BILLBERGIA

**STAGES 2A & 3A
WALKER STREET RHODES**

ACCESS REVIEW

10th November 2010

1 DETAIL PLAN
BLDG A - Apartment Type 2-A
Pre Adaption Layout

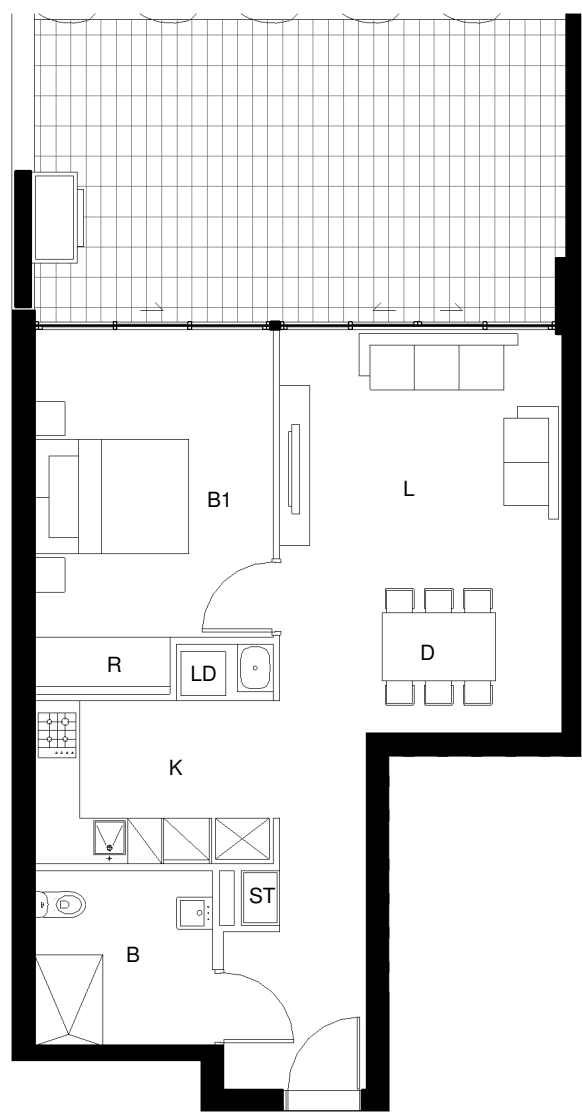
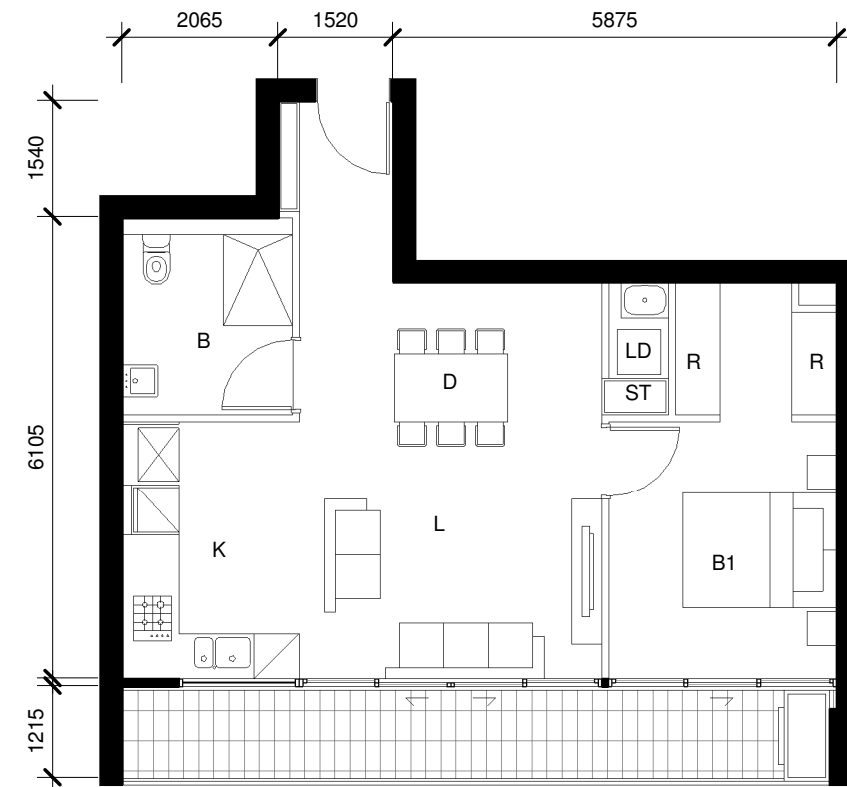
The entry door has 850mm clear width and 510mm latch side clearance on the internal side of the door, compliant with AS1428.2 and AS4299.

Bedroom and bathroom doors have a clear width of 820mm, compliant with AS4299. There is potential to increase doorway circulation areas compliant with AS1428.1

The bedroom has internal dimensions of 3000mm x 3700mm (outside wardrobe space) with at least 1000mm on each side of the bed and the potential to provide increased circulation area (1540mm x 2070mm) at side of the bed, compliant with AS1428.2.

The bathroom appears to have internal dimensions of 2300mm x 2250mm. The bathroom (shower, toilet, wash basin) has potential circulation area requirements in accordance with AS1428.1. Further review of proposed shower/bath screening is required to ensure the 'visitability' of toilet is in compliance with AS4299.

The L-shaped kitchen layout provides appropriate 1550mm clearance between base cabinets, compliant with AS4299. There is an appropriate 800mm workbench adjacent to the cook top and sink in compliance with AS4299. There is a set-down space provided (500mm) adjacent to wall mounted oven which will satisfy AS4299.

The laundry has 1550mm diameter circulation area in front of laundry appliances compliant with AS4299.

7 DETAIL PLAN
BLDG C - Apartment Type 1-A
Pre Adaption Layout

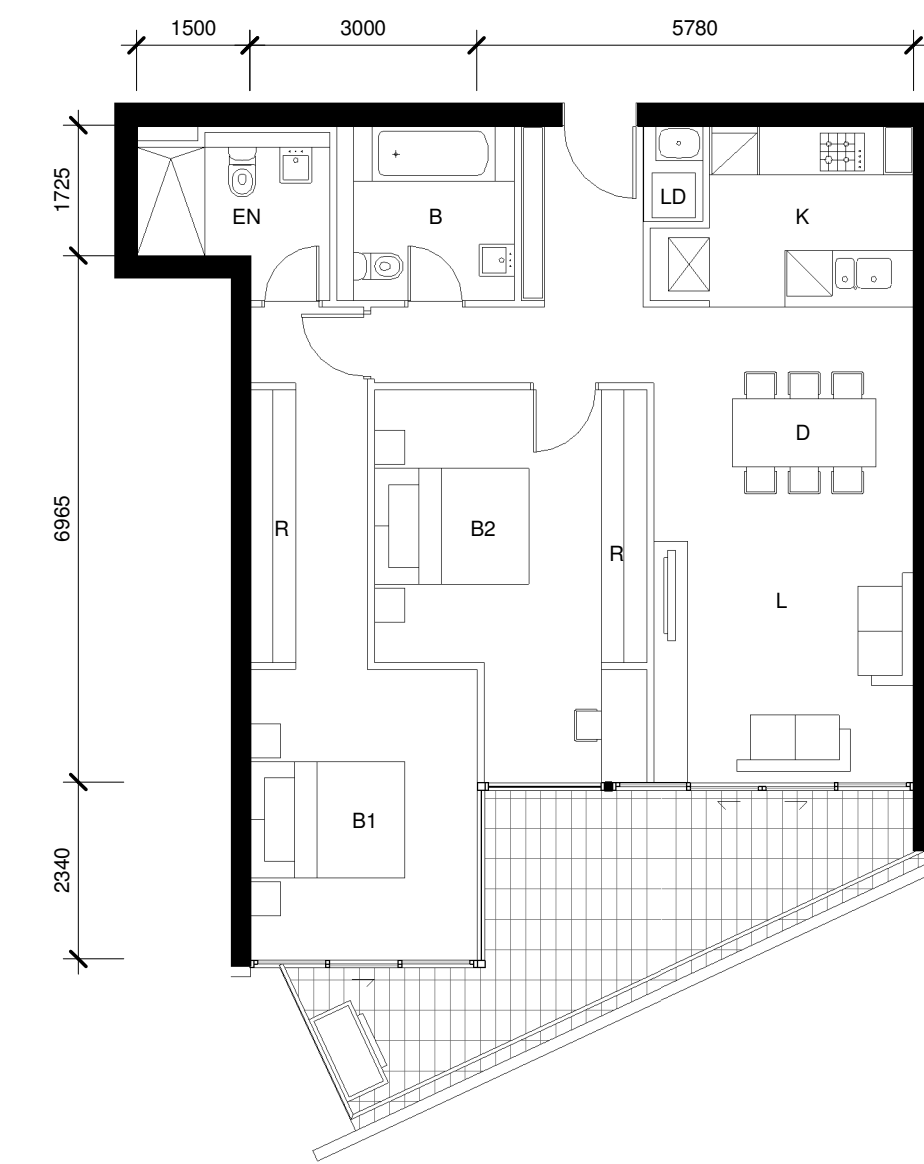
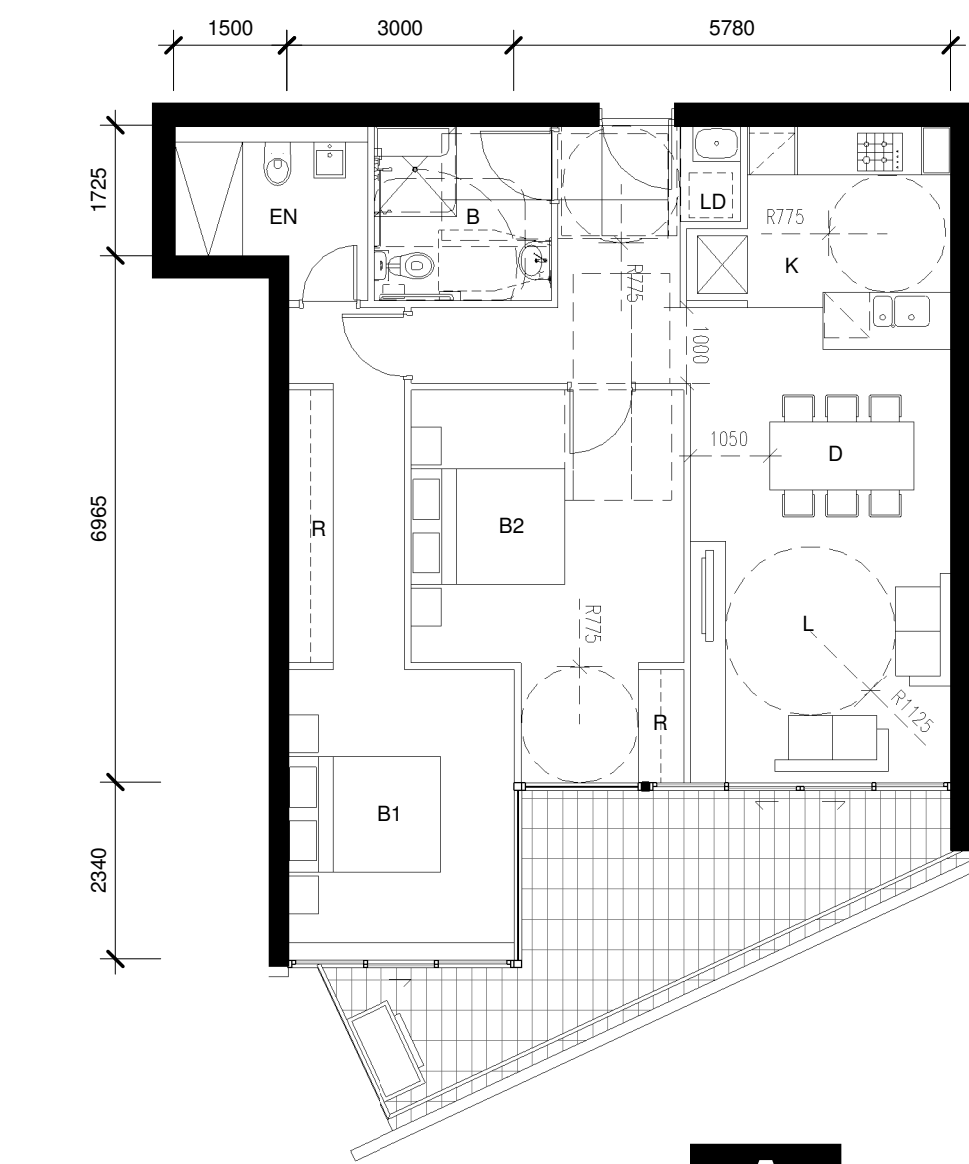
The layout has appropriate entrance circulation areas in accordance with AS4299. The entry door has appropriate width and can achieve latch side clearances under AS4299.

The internal corridors have suitable width under AS1428.1. The internal doors have appropriate width. The bedroom door can achieve latch side clearances as dictated under AS4299.

3 DETAIL PLAN
BLDG A - Apartment Type 7-A
Pre Adaption Layout

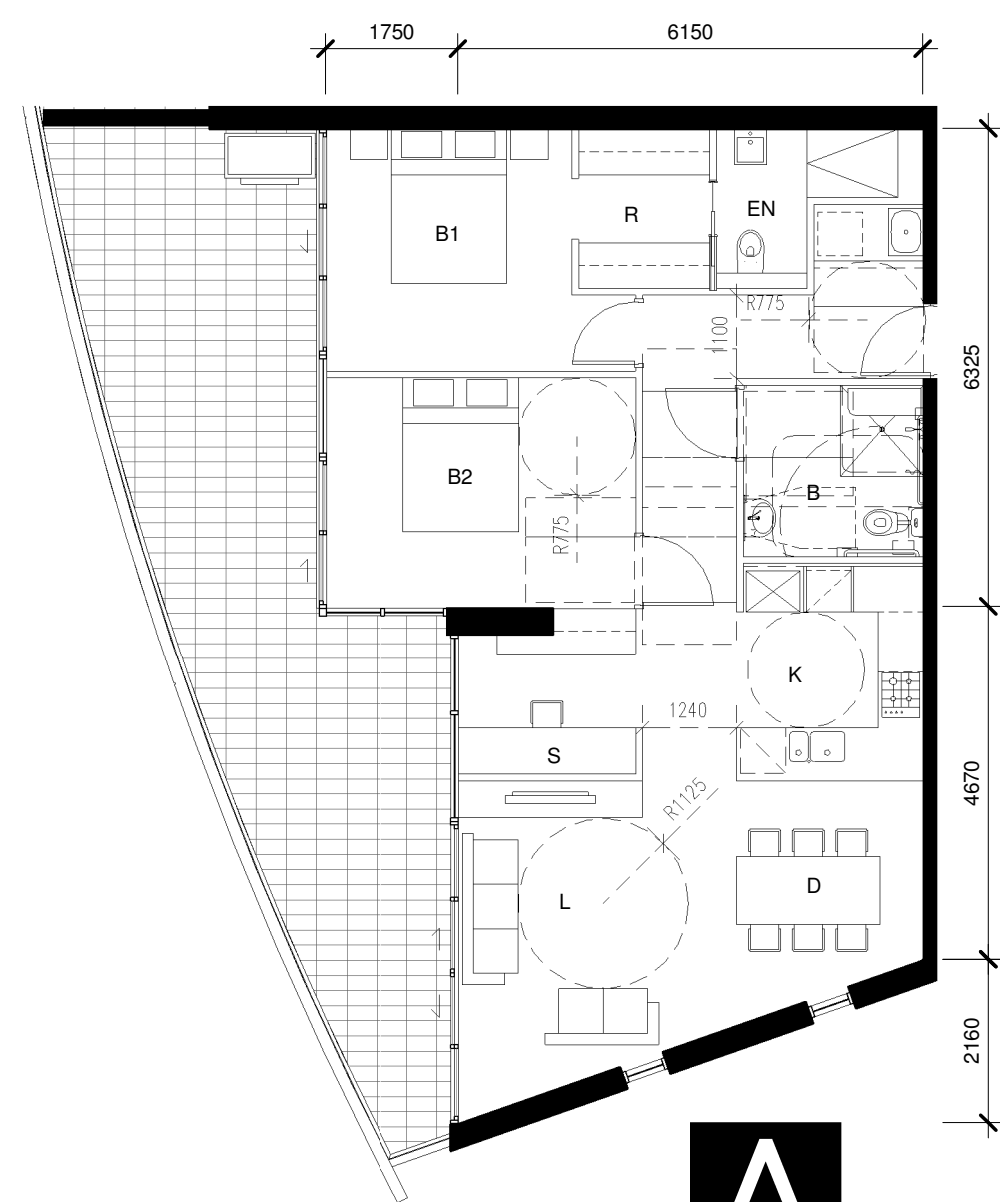
The layout has appropriate entrance circulation areas in accordance with AS4299. The entry door has appropriate width and latch side clearances under AS4299.

The internal corridors have suitable width under AS1428.1. The internal doors have appropriate width and have latch side clearances as dictated under AS4299.

The living areas have suitable circulation areas under AS4299.

The L-shaped kitchen layout provides appropriate 1550mm clearance between base cabinets, compliant with AS4299. There are appropriate workbench adjacent to the cook top, oven and sink in compliance with AS4299.

The bathroom en-suite has appropriate internal dimensions that will satisfy circulation areas of pan, basin and shower under AS1428.1.

The main bedroom has appropriate circulation areas under AS4299. The laundry area has suitable circulation area in front of the laundry appliances.
